OFFICIAL NOTIFICATION OF DECISION

Project# PR-2020-003658
Application#
SI-2020-01052 EPC SITE PLAN FINAL SIGN-OFF

All or a portion of **TRACT 4, NORTH ANDALUCIA AT LA LUZ**, zoned PD, located at **5301 ANTEQUERA RD NW between BOSQUE SCHOOL RD and MIRANDELA ST**, containing approximately 7.7061 acre(s). (E-12)

SITE PLAN
 1" = 40'

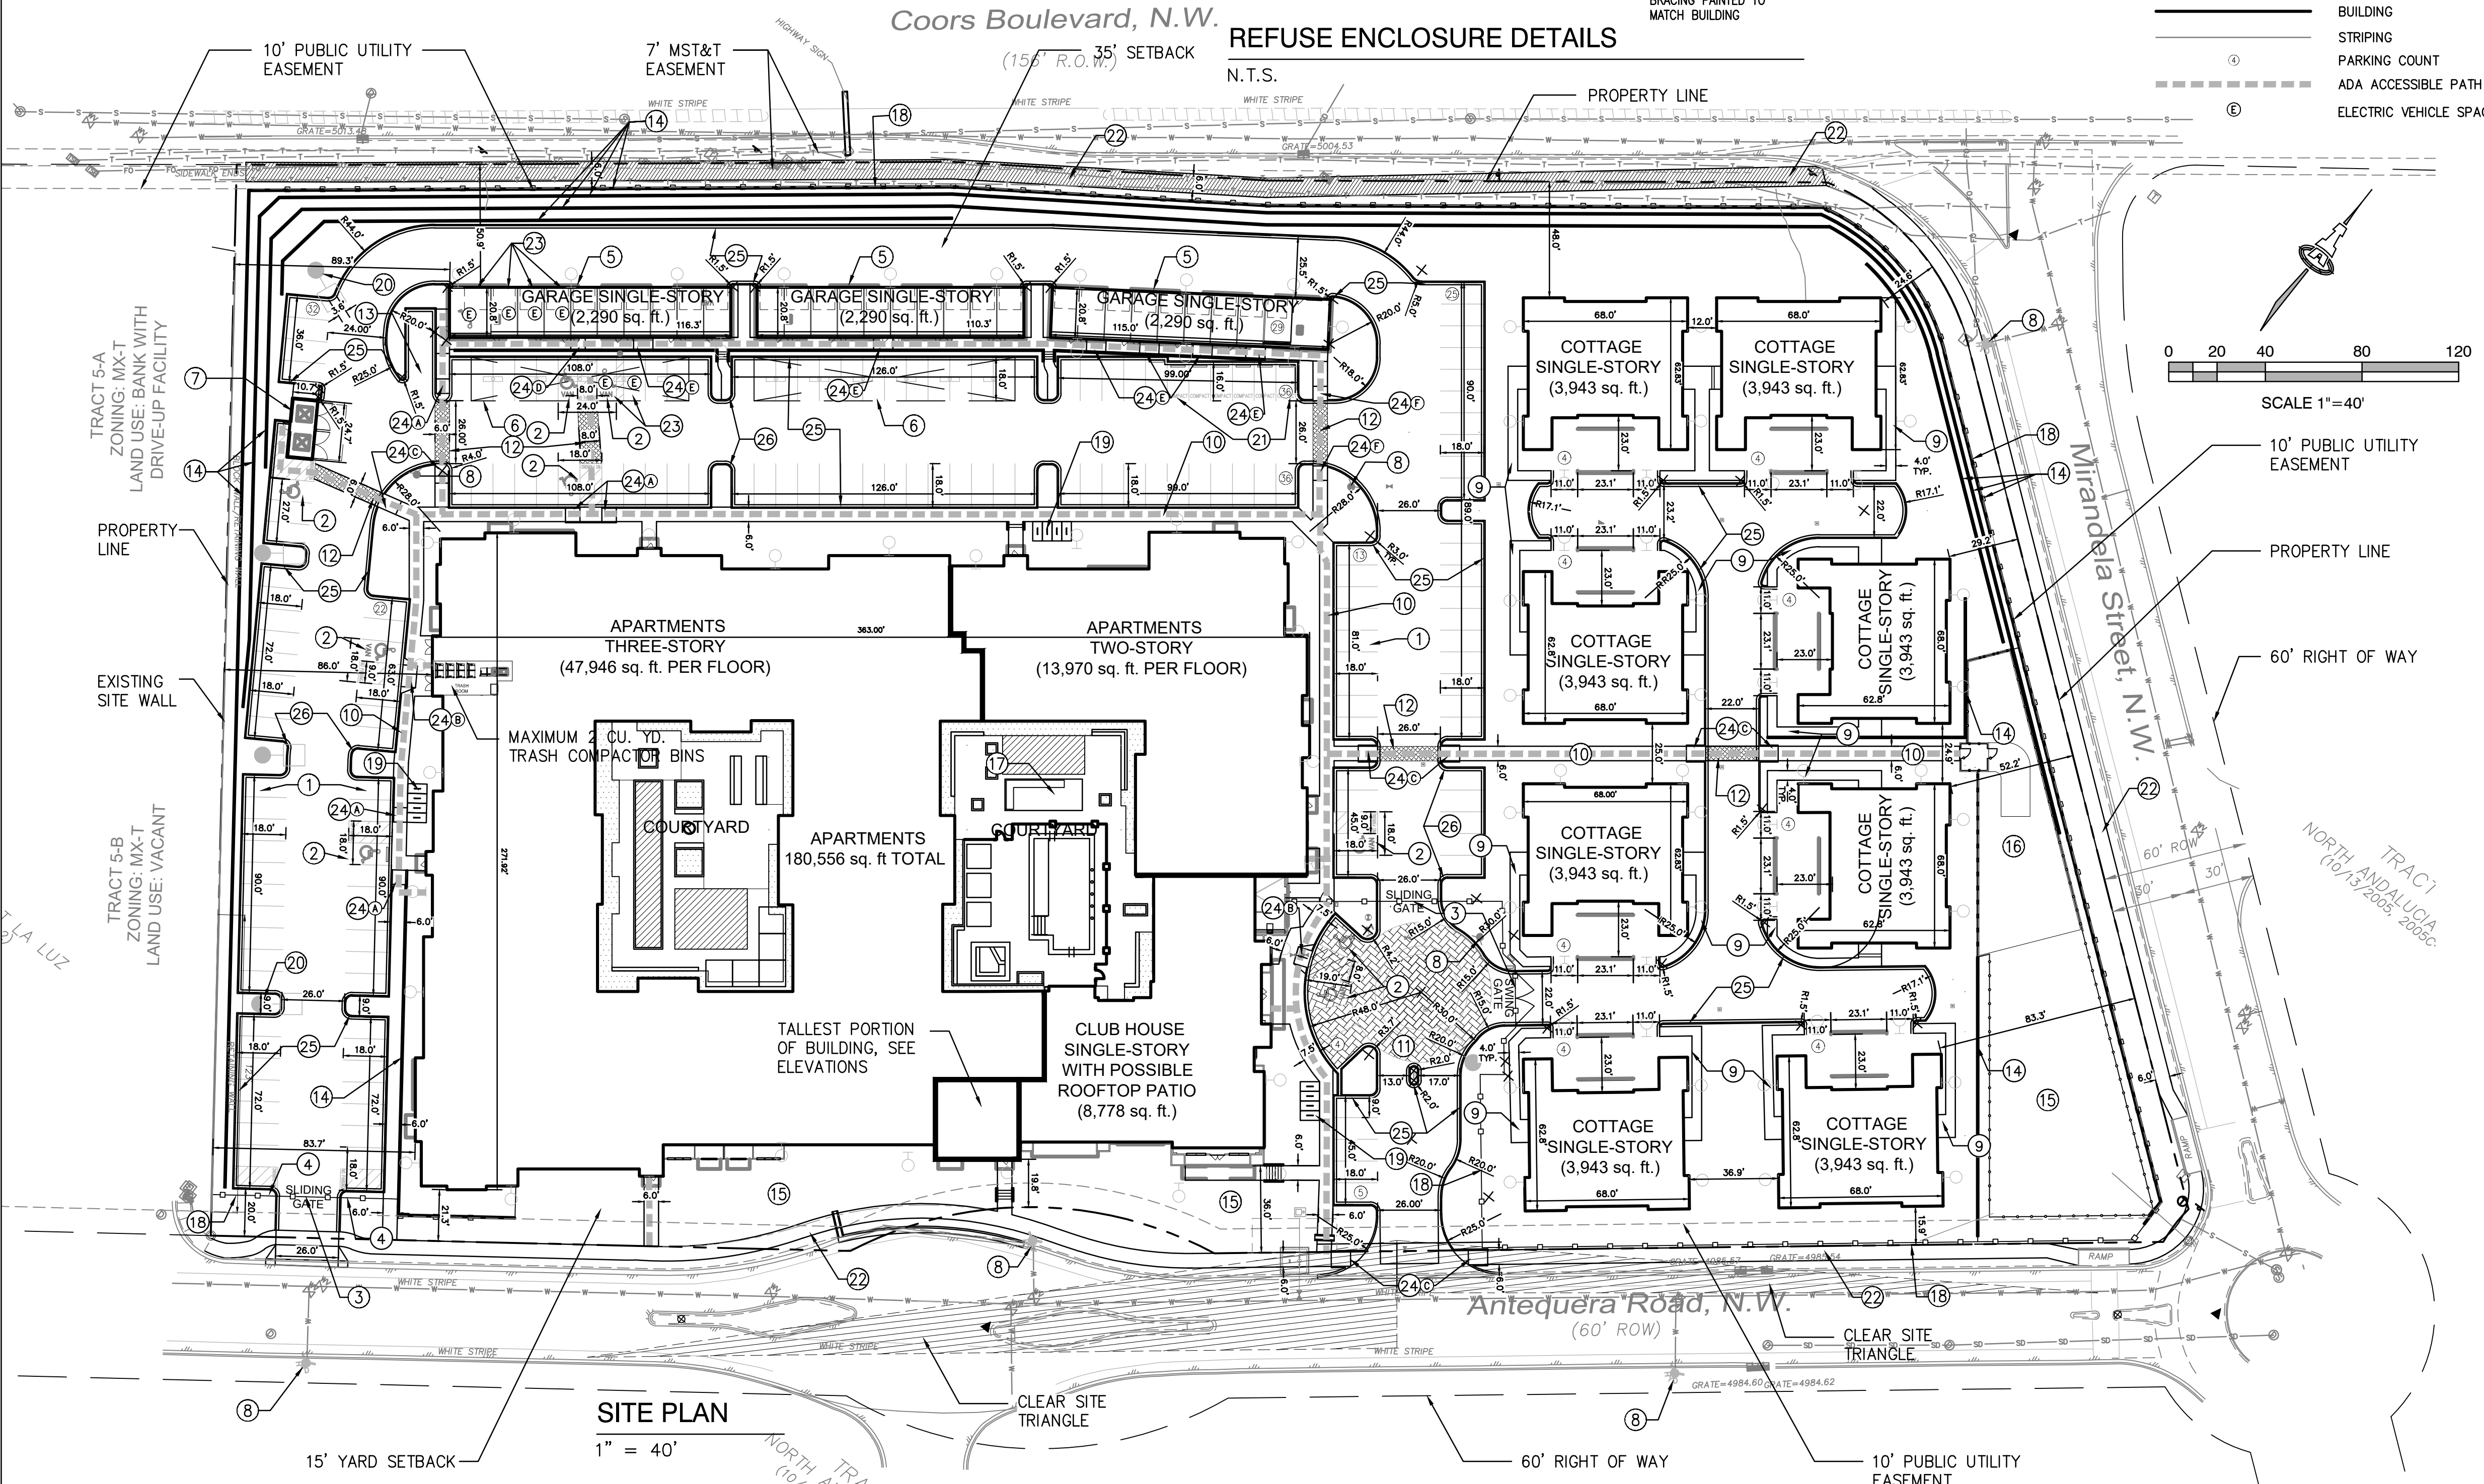
1. Final sign-off is delegated to Transportation for a note on the Site Plan for a landing at the top of the perpendicular ramps.
